From: clerk@longridge-tc.gov.uk
Sent: 25 May 2023 20:18
To: Planning
Subject: Fwd: Application 3/2023/0309 - Proposed installation of signs

RE: Application 3/2023/0309 - Proposed installation of externally illuminated fascia sign and externally illuminated hanging sign.

PROPOSED FRONT ELEVATION

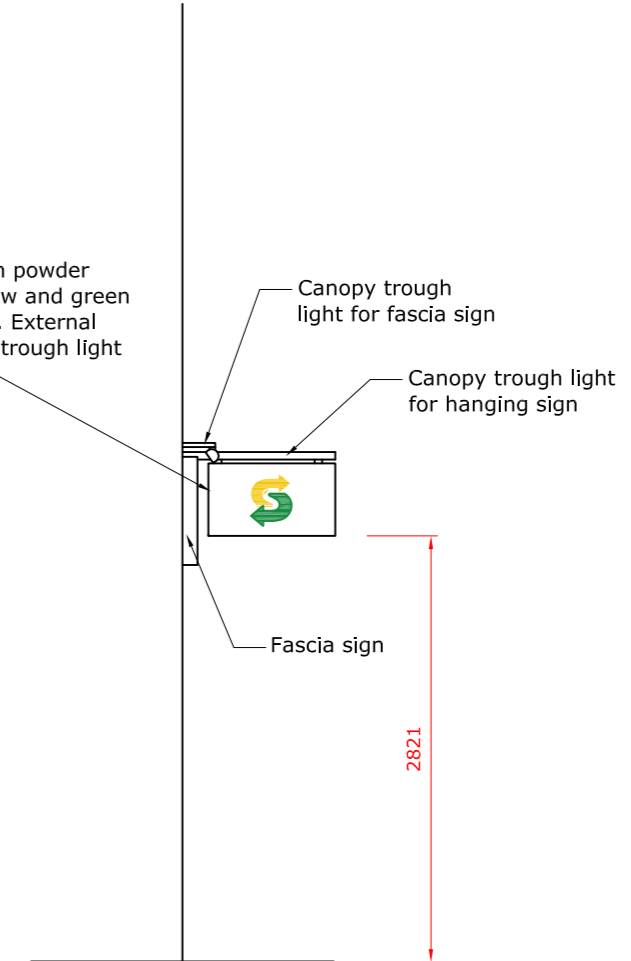
The sign that has been proposed and subsequently erected despite not having been granted permission from planning does not meet the criteria set out in the document for the following reasons:

- The sign is not in keeping with the character of the area because of the general design that is used at Subways in cosmopolitan areas and does not account for the tradition, heritage, and charm of the high street set in a conservation area.
- The sign is over-intensive because of the font size relative to the sign's area, the bold/bright colours used, and the gaudy white background.
- The aluminum sign tray with S/A Vinyl letters does not reflect the character of the conservation area because they are modern and no consideration has gone into even trying to replicate traditional craftsmanship or portray the characteristics or heritage of the conservation area.

The old Swifts building is listed as a 'building of townscape merit' and because of this any sign that is fixed to the building should seek to enhance the appearance of the facade and wider townscape. In my opinion, the current sign does not.

I would like to propose that the planning committee recommends to the Town Council makes recommendations to the applicant that the sign should be changed to reflect the standards set in the 'Longridge Conservation Area Management Guidance' and to that of the character of our town.
